Our Ref: AWE200083-L01: BCP/bcp
Contact: Dr Brett C. Phillips

22nd February 2021

RESPONSES TO FLOODING SUBMISSIONS, ASPECT INDUSTRIAL ESTATE, KEMPS CREEK, NSW

Figure 10 2 yr ARI Flood Velocities - Stage 1 Conditions

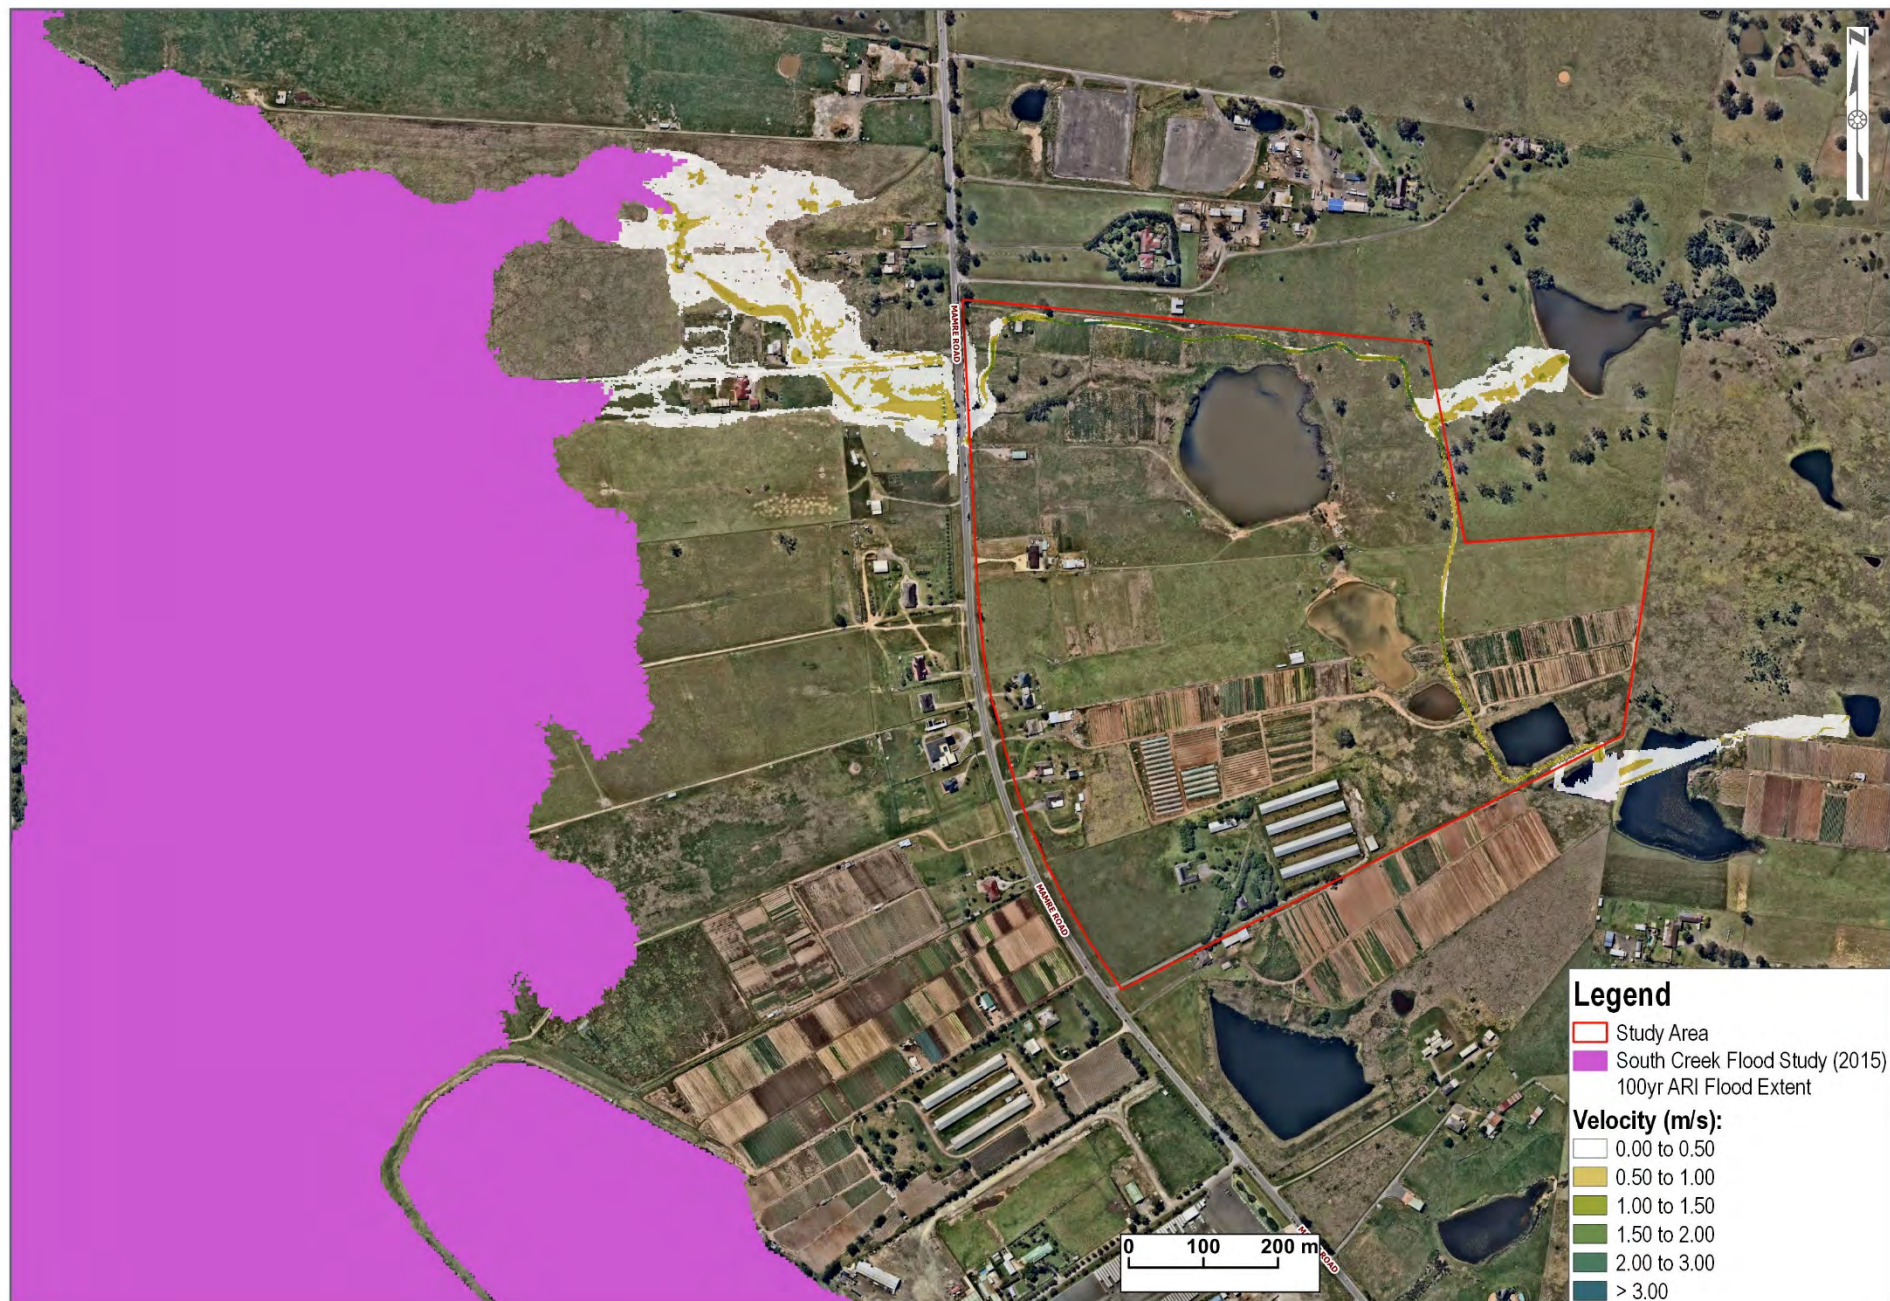
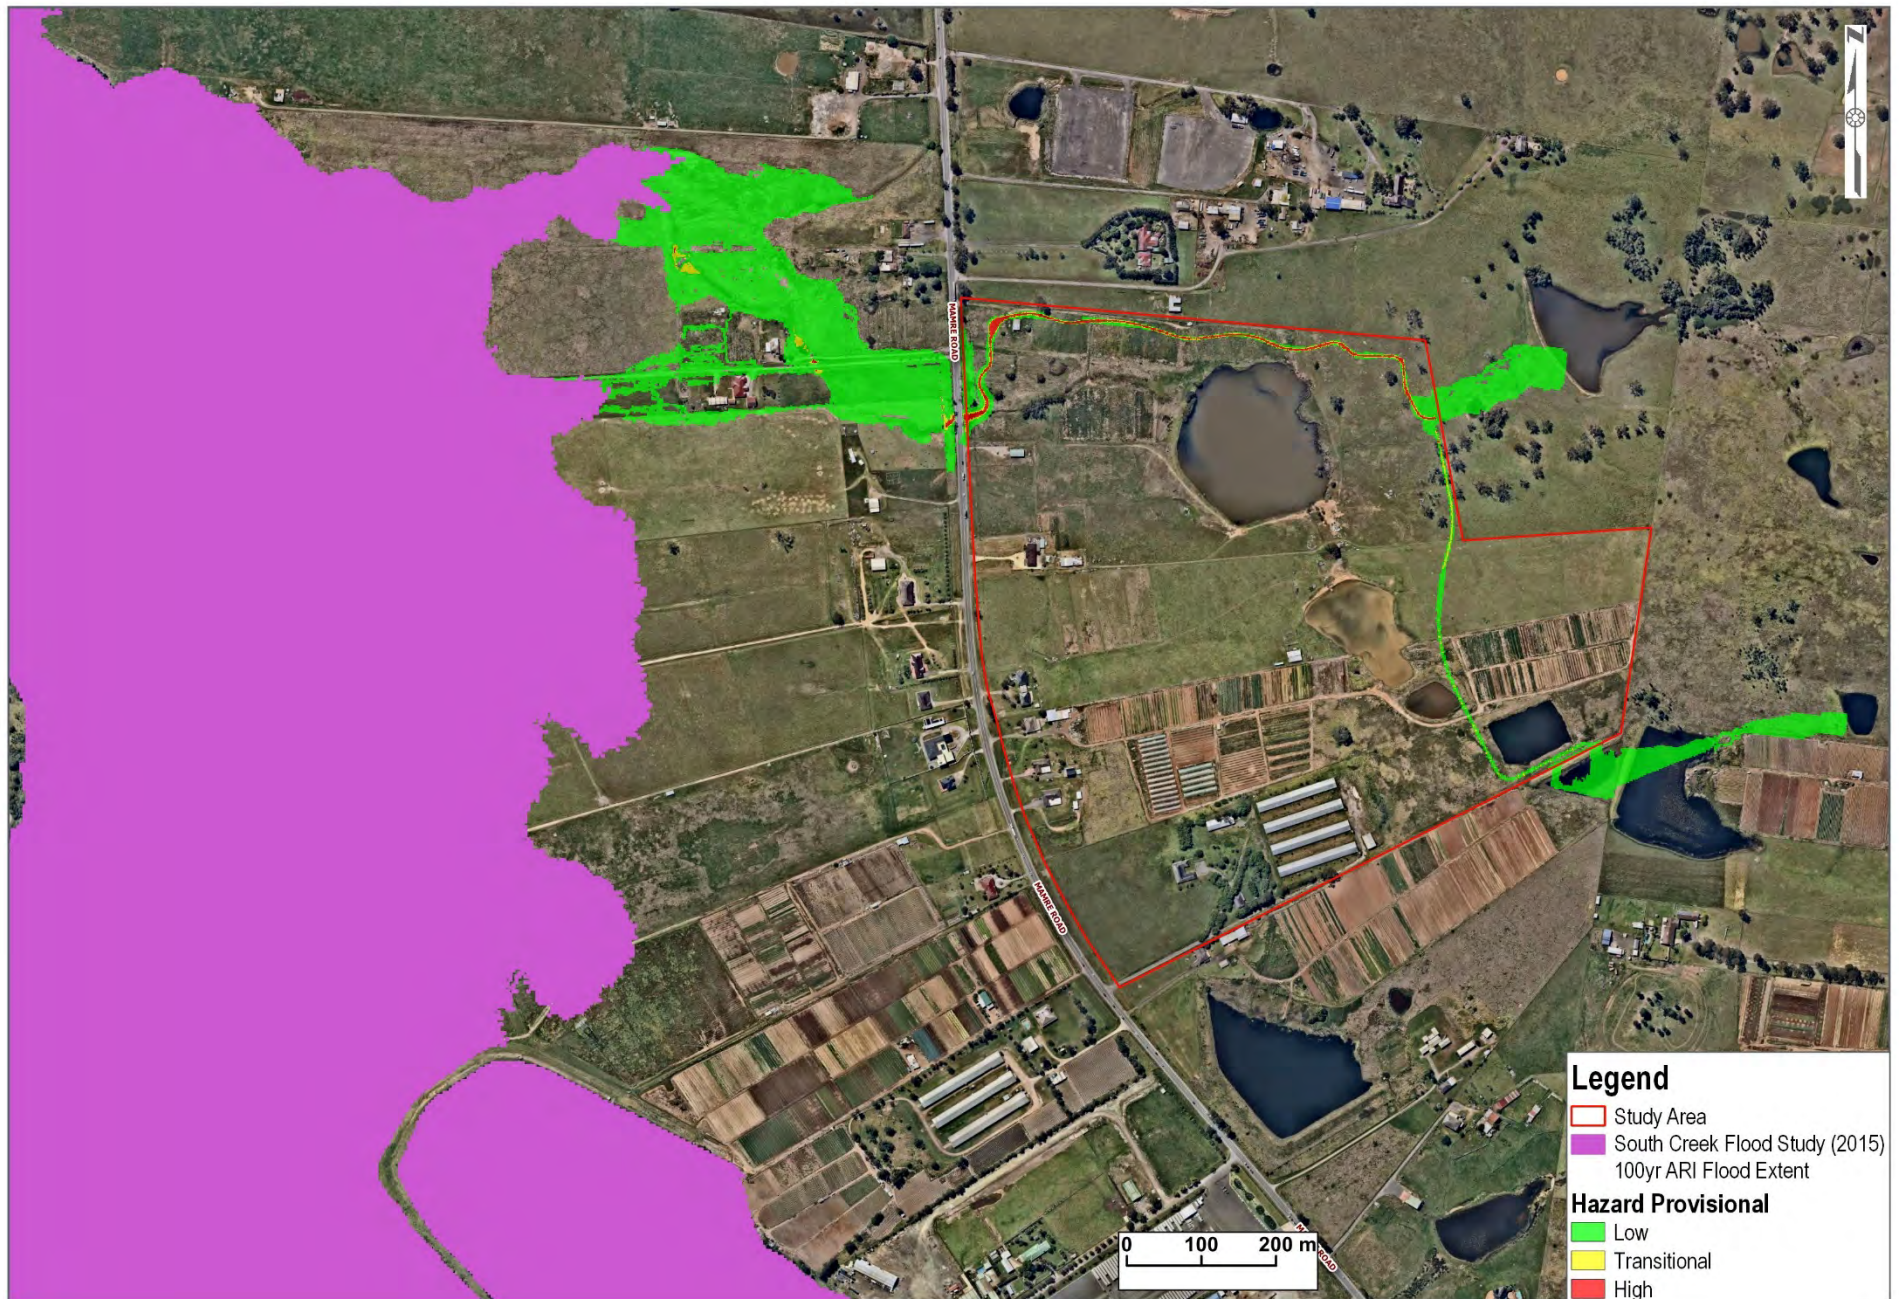
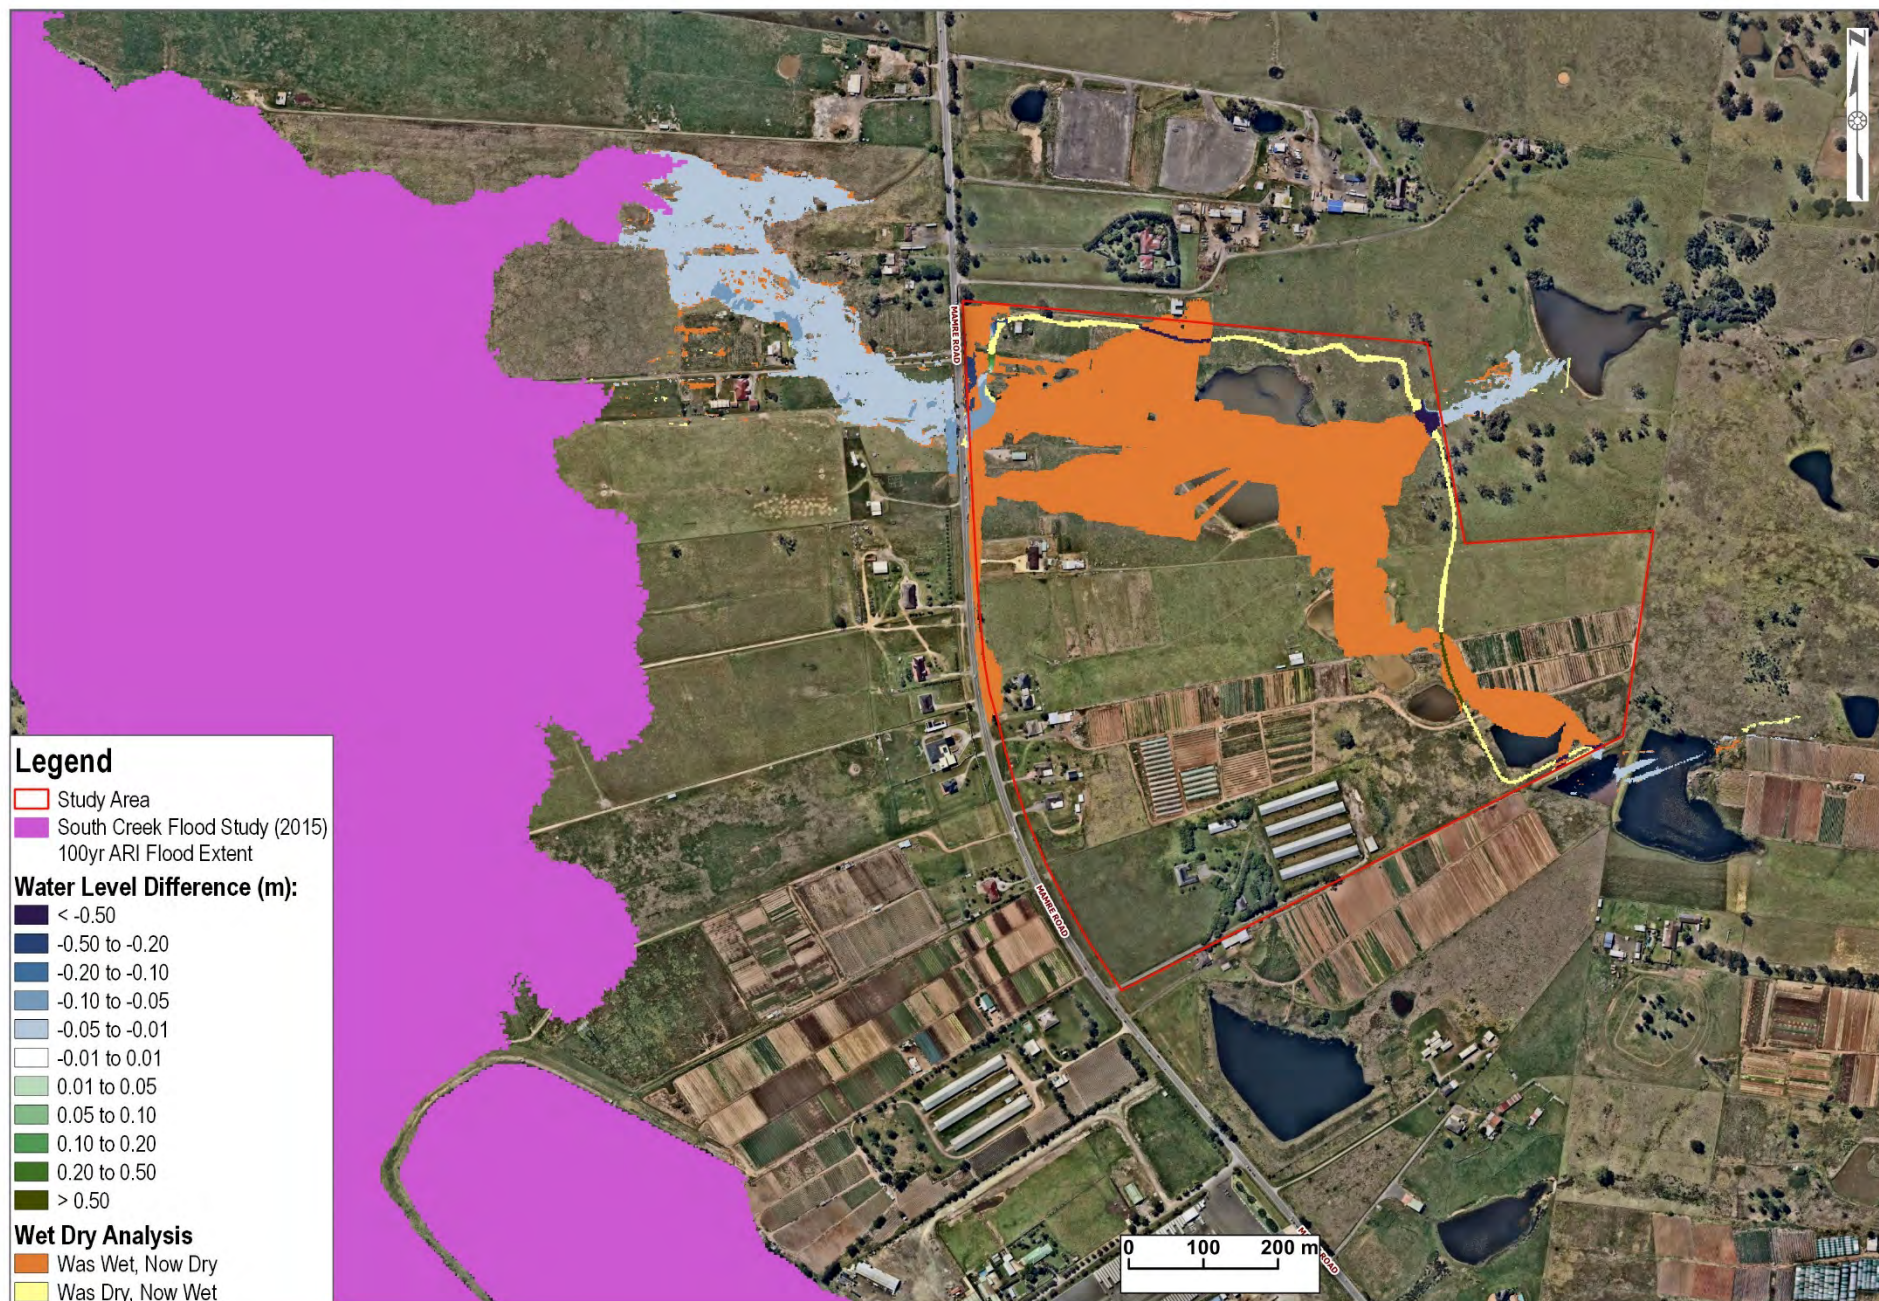
- *The developed scenario maps present local overland flow for Stage 1 which comprises of two industrial lots on the northern part of the site. However, from a flow management perspective, an overland flow study should consider the ultimate developed scenario of the site instead of considering each progressive development independently.*

- *All maps for developed conditions should properly depict the layout of the development, locations of proposed constructed channels and the location of the proposed detention basin.*

The final masterplan has been assessed and the results of the assessment have been incorporated into an updated version of the FIA report.

The updated Figures have been incorporated into an updated version of the FIA report.
